GM Urban Design & Architecture  
Studio 803, Level 8  
75 Miller Street  
North Sydney NSW 2060

Date: 17/12/2015

**Re: State Significant Development Application and Variation of the Sydney Cove  
Redevelopment Scheme for the 'Remediation, Renewal and Adaptive Re-Use of Campbell's  
Store', The Rocks (SSD 7056).**

PROPOSED SCRA Amendments highlighted in red nominating plan envelope of building

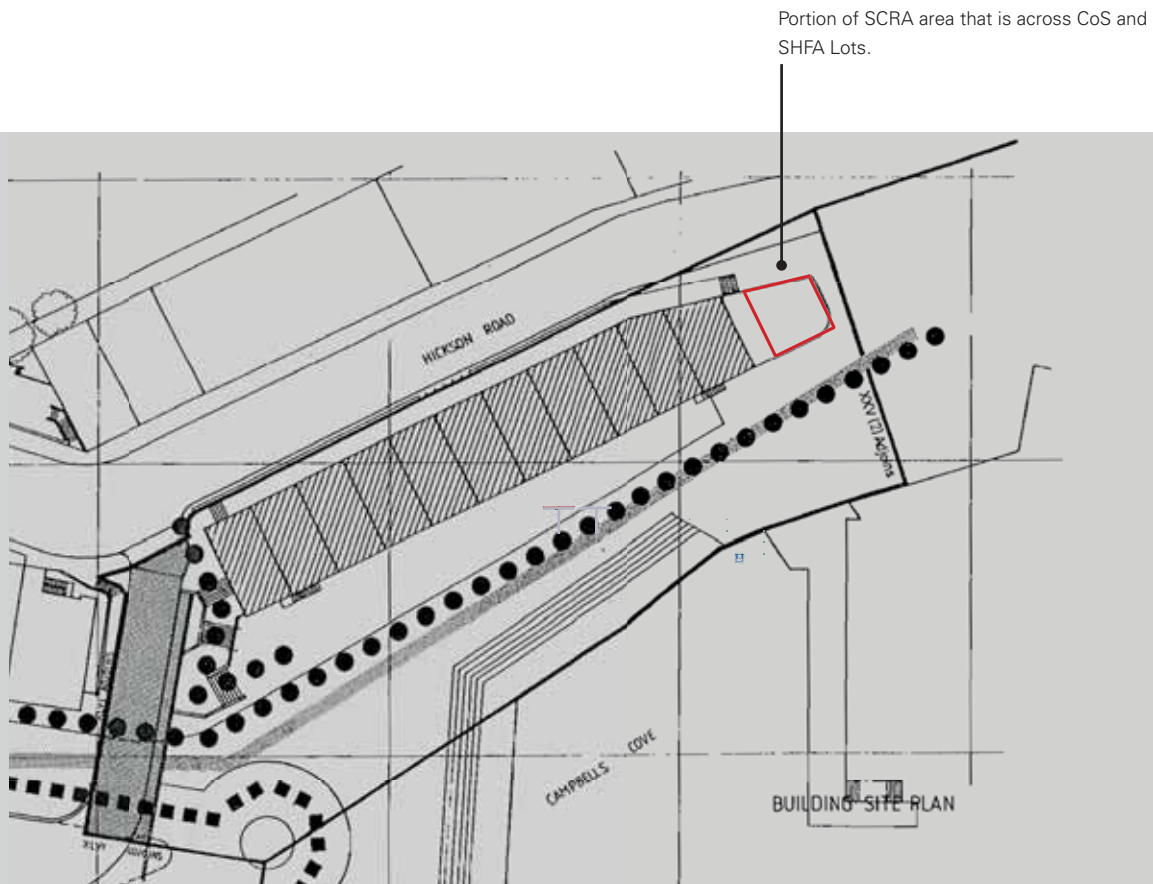
The site is affected by a height limit under the Sydney Cove Redevelopment Authority Scheme – Building Site Control drawing XVII. This indicates the maximum height of any structure beyond the heritage building. The diagram is shown below for reference. It illustrates that any structure on the northern end of the site is not to exceed an RL of 7.5m towards the west and RL 3.5 towards the east. These heights only allow for a structure of approximately 3m to the west and 0.5m on the site.

This application seeks to amend the building envelope diagram over the site to a proposed maximum height of RL 18. This is an increase in height of 10.5m to the west and 14.5m to the east.

Drawing Title  
**SITE PLAN**  
**PROPOSED**  
 JPW Project Number  
**12006**  
 Drawing Status  
**EA**  
 Drawing Number  
**EA-A-002**  
 Revision  
**B**

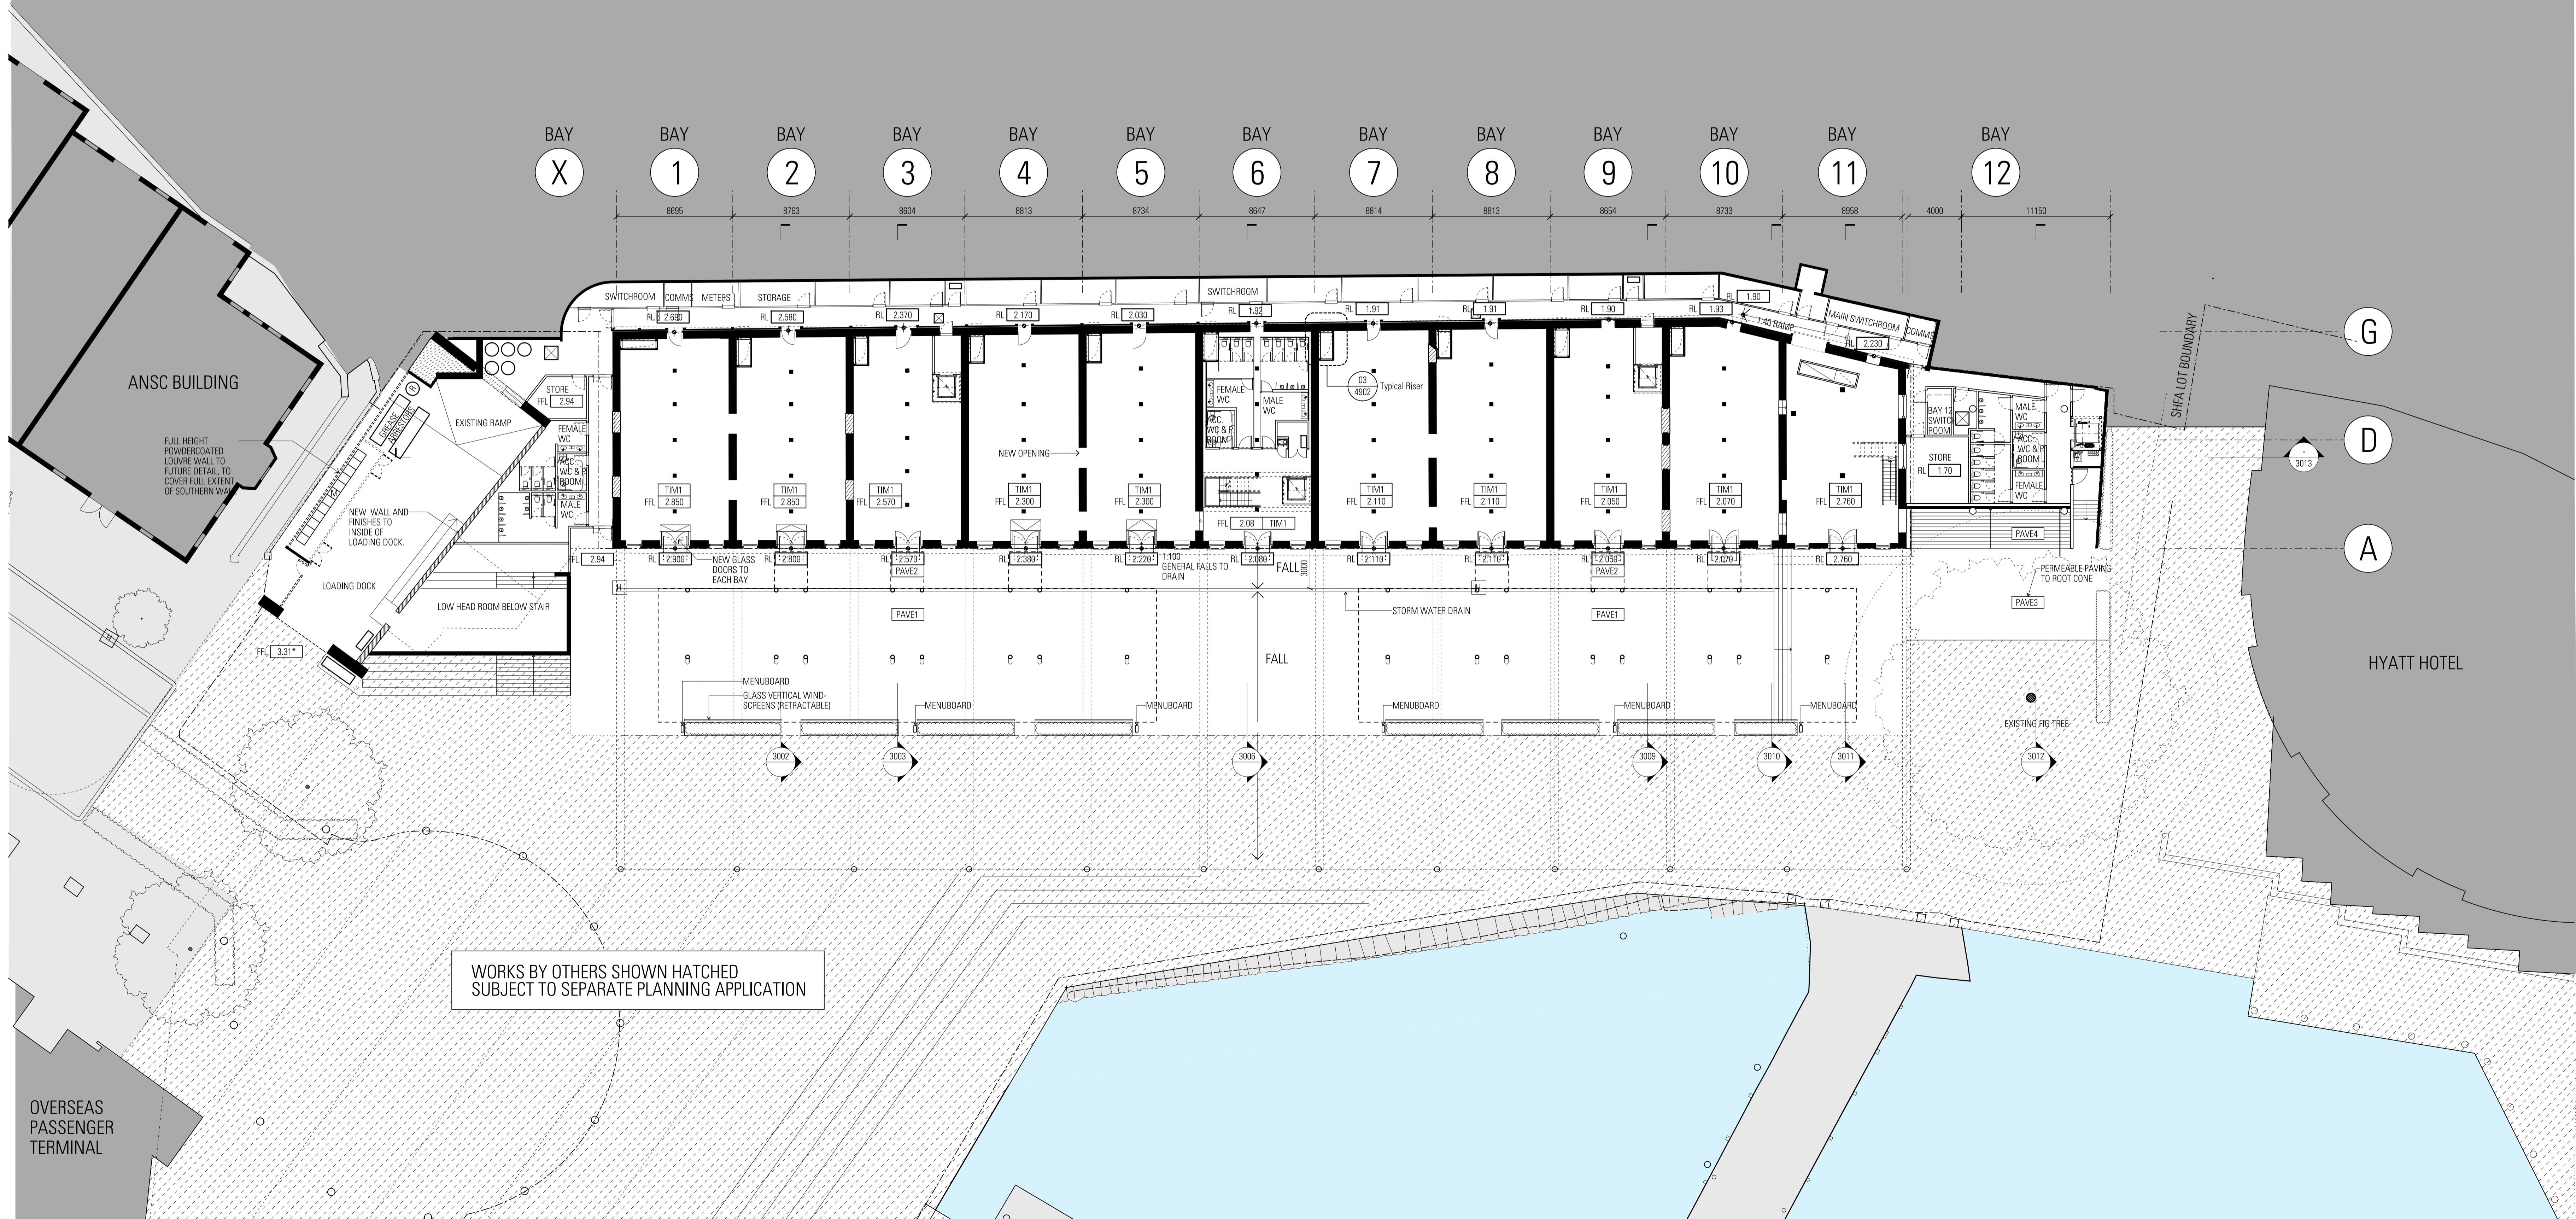
The proposed outdoor dining area with the new awning structure only partially meets the CMP's guidelines with regards to the removal of the existing shading and masts. However, the proposed area is only 3m away from the eastern façade, which would not provide the '*generous public walkway*' which was recommended along the eastern

façade in the Conservation Management Plan. The dining area has been increased in comparison to the existing space. There is also a new dining space on the Hickson Road frontage. It is considered that the new area to Hickson Road should facilitate a reduction to the dining on the waterside to allow greater separation and additional pedestrian space and so to comply with the guidelines of the CMP.

Currently the existing sequence of spaces between the buildings along the foreshore is regular with an average 20-25m separation distance. The proposed building will decrease the distance in this location to approximately 10m to the north. It will not only disturb the outlook from the Park Hyatt Hotel's balconies but also create an impression of density and scale that is not in keeping with character of the area. It will create an impression of overdevelopment by restricting the rhythm of space to built form.

The arborist report as part of the application indicates a Tree Protection Zone (TPZ) area requirement with a 12.8m radius. The proposed structure needs to be setback from the alignment with the eastern edge of Bay 11 by approximately 2m. It is also understood that some pruning of tree branches will be required to allow for construction of the building. The existing East West canopy spread indicated in the arborist's report is 28m diameter (14m radius). This suggests at least 4m of the tree would require pruning, significantly impacting the girth of the tree.

GMU has reviewed the submitted documentation, the relevant controls and inspected the site and the surrounding area. Based on our analysis, the understanding of the desired character for the area and the urban design principles, we consider that the proposed changes to the eastern façade of Campbell's Stores are appropriate. From our urban design perspective, the only change to this part of the scheme we would suggest would be an increase to the distance between the new awning structure of the dining area and the eastern façade.

Drawing Title  
**ELEVATIONS**  
JPW Project Number  
12006  
Drawing Status  
EA  
Drawing Number  
EA-A-2000  
Revision  
B

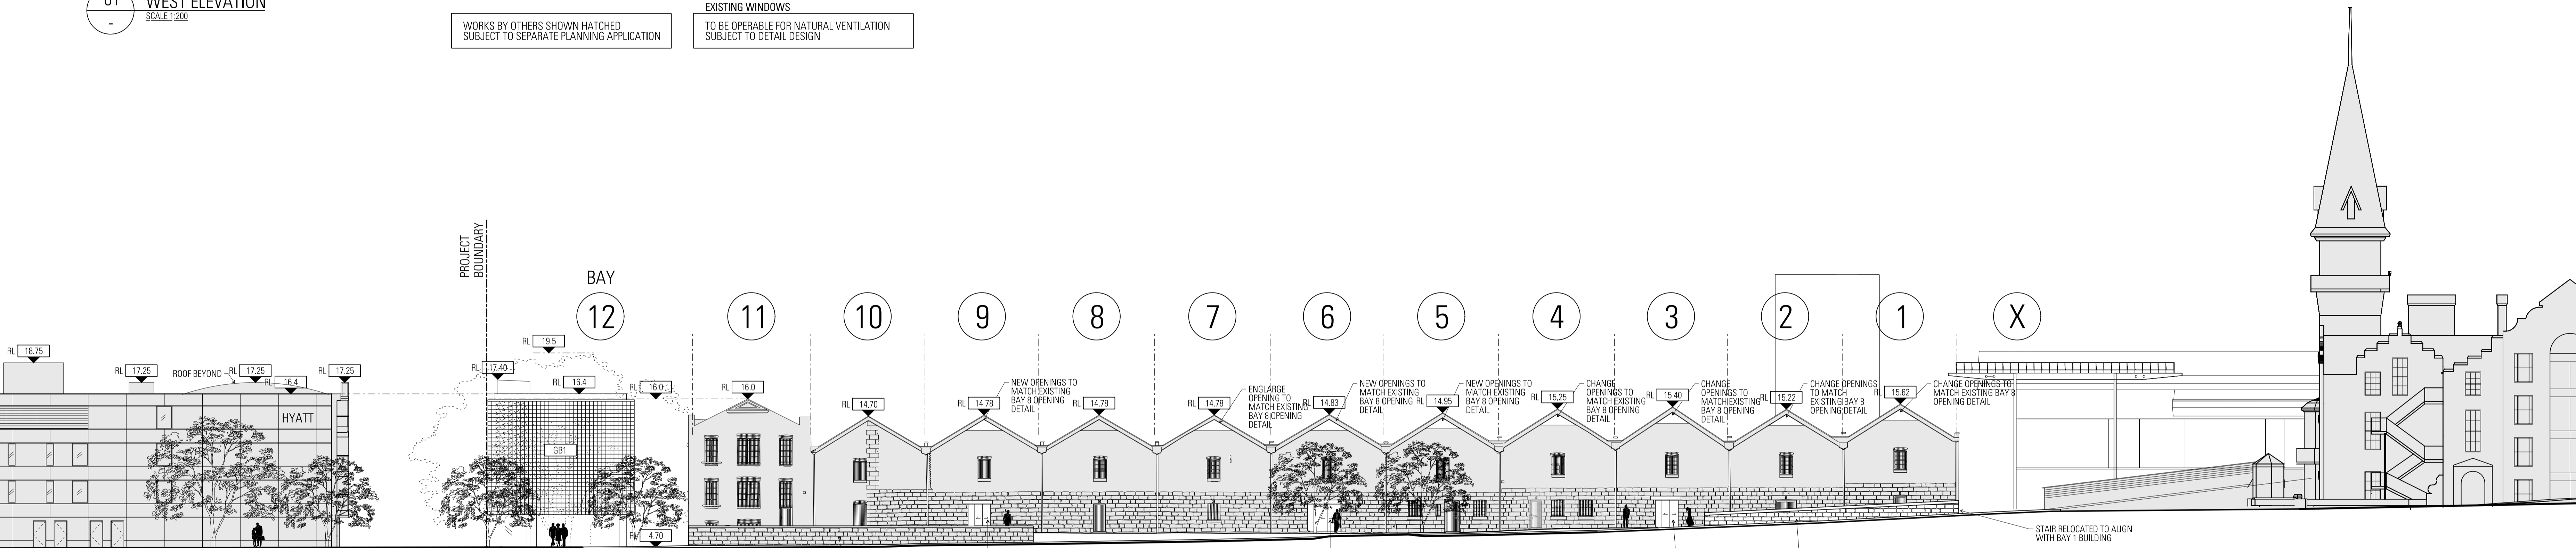
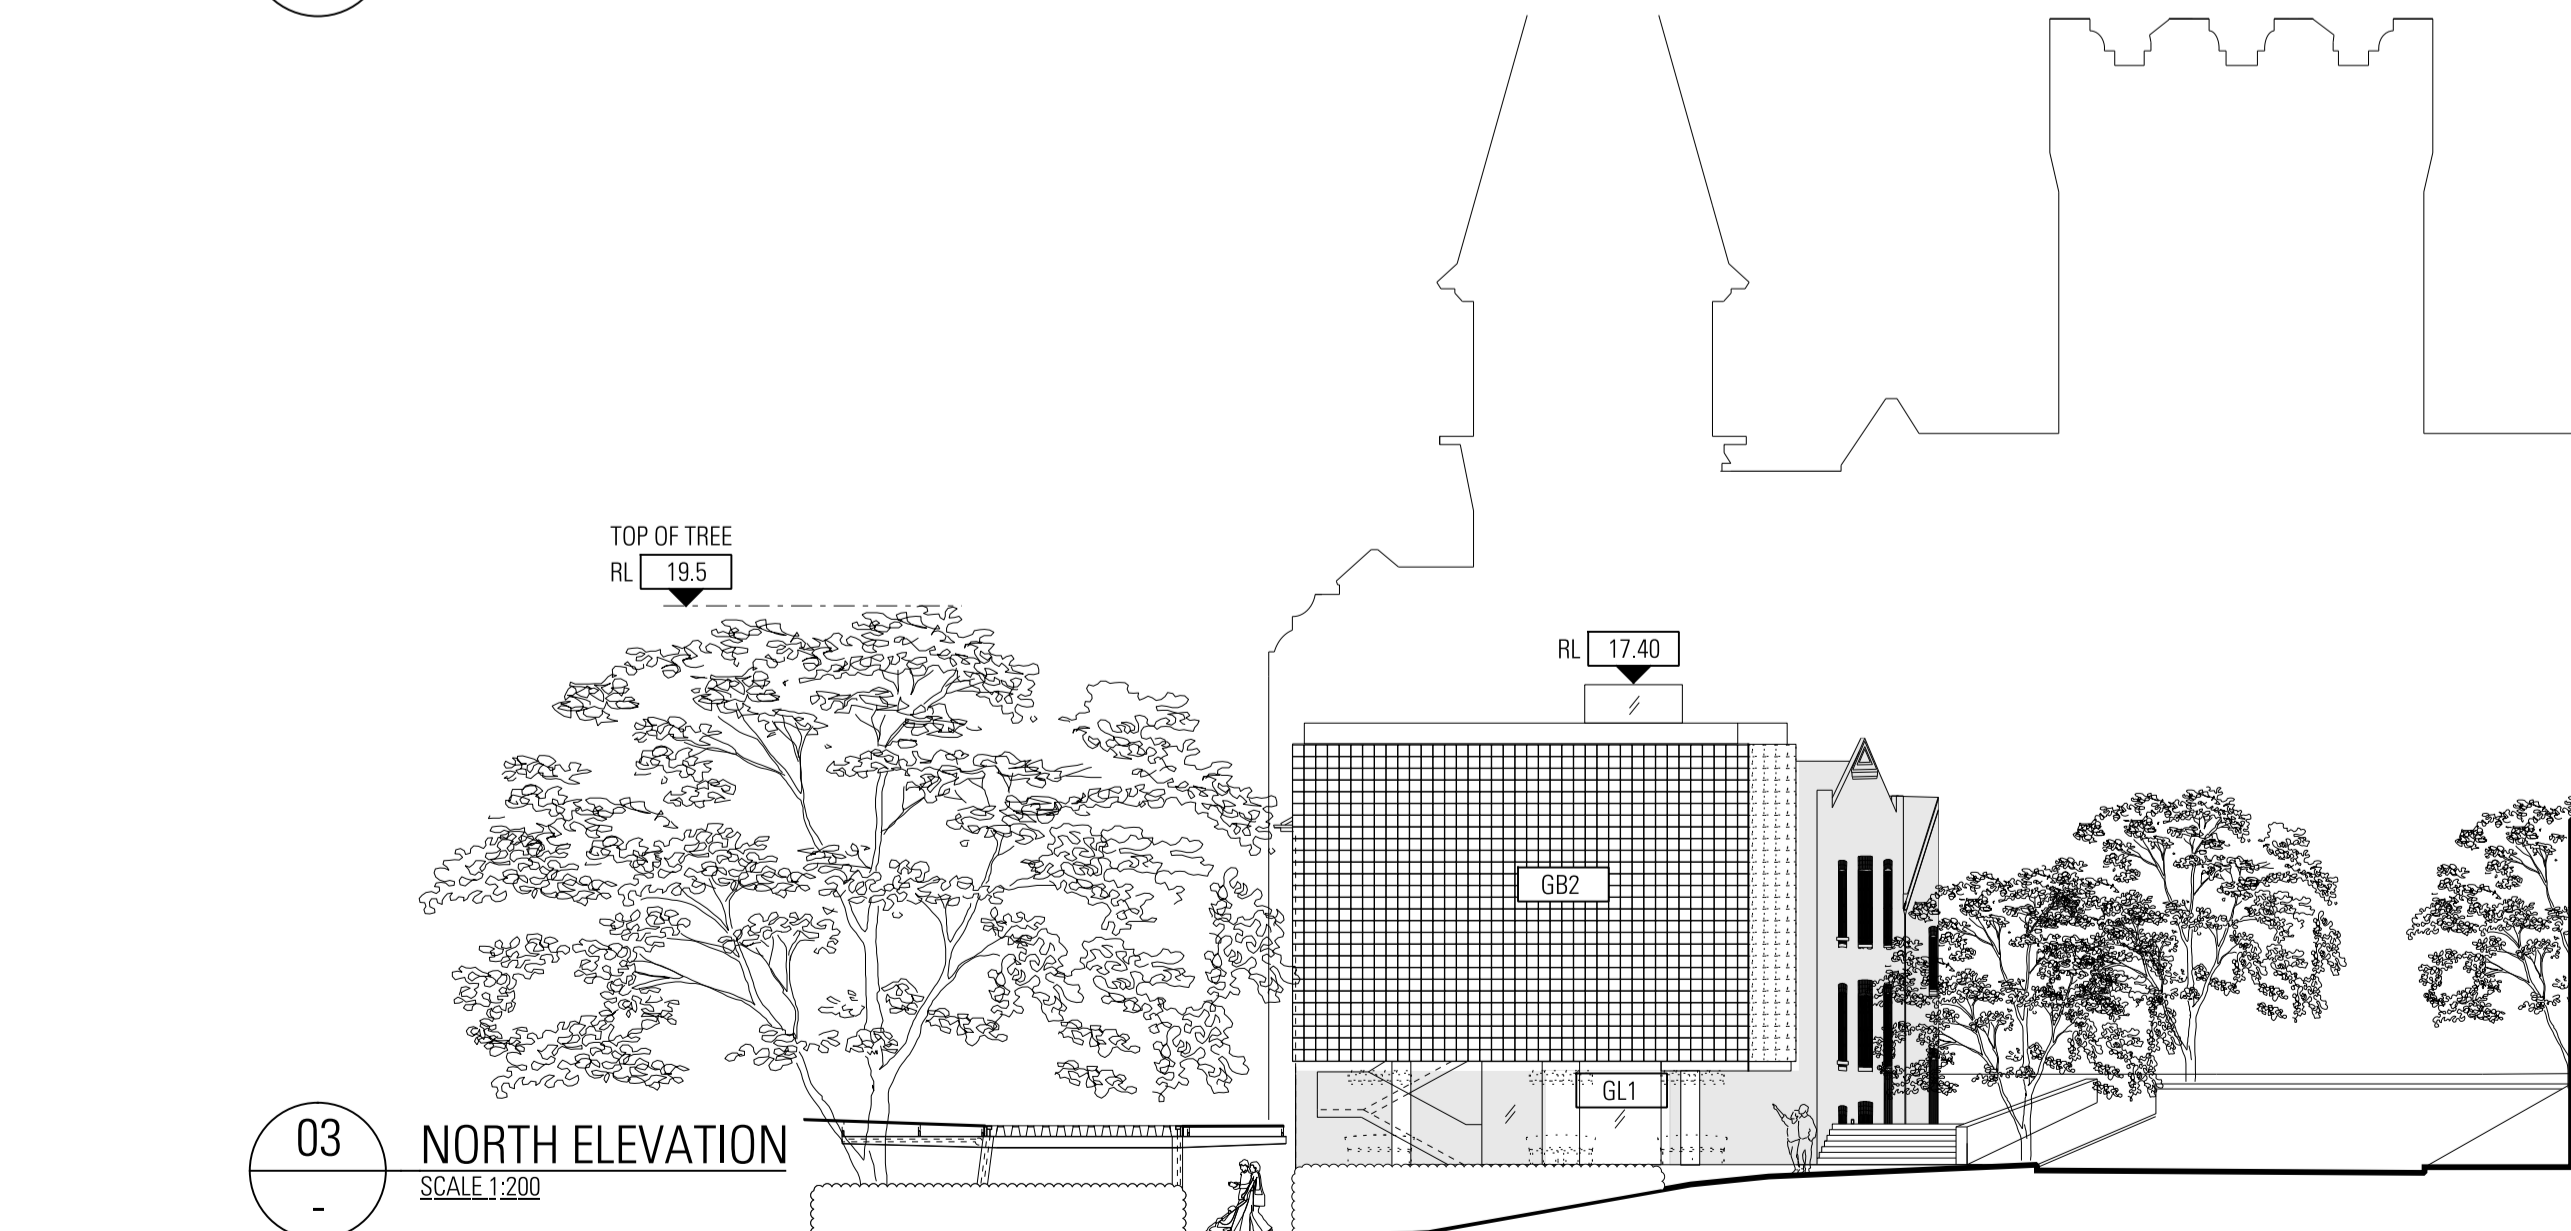
The proposed 'glass box' is not sympathetic to the existing materials or the established rhythm of the stores. It is a rectangular form with horizontal emphasis whereas the other bays have a vertical emphasis. Bay 12 has a flat roof that is not in keeping with the characteristic pitched roof forms along Campbell's Stores. The use of glass blocks is also uncharacteristic in the area.

The heritage character surrounding the site means that any new structures should not detract from the heritage significance of the foreshore or the appreciation of its heritage items. The form of the proposed building detracts from the character of the area due to its excessive height and unsympathetic proportions. The proposed height is greater than Bay 11 and the hotel, making the proposed structure the most significant building on the eastern edge of Hickson Road. The impact of the ground level undercroft to the windows of the heritage stores is also unsympathetic in terms of alignment, volume and outlook as can be also seen in the photomontage.

It is unclear how the proposed increased ground level of the area at Bay 12 is going to be detailed at its junction with the northern façade of Bay 11. It appears to abut the existing windows and doors as is also shown in following photomontage.

GMU recommends the proposal is amended to exclude the 'glass box'.
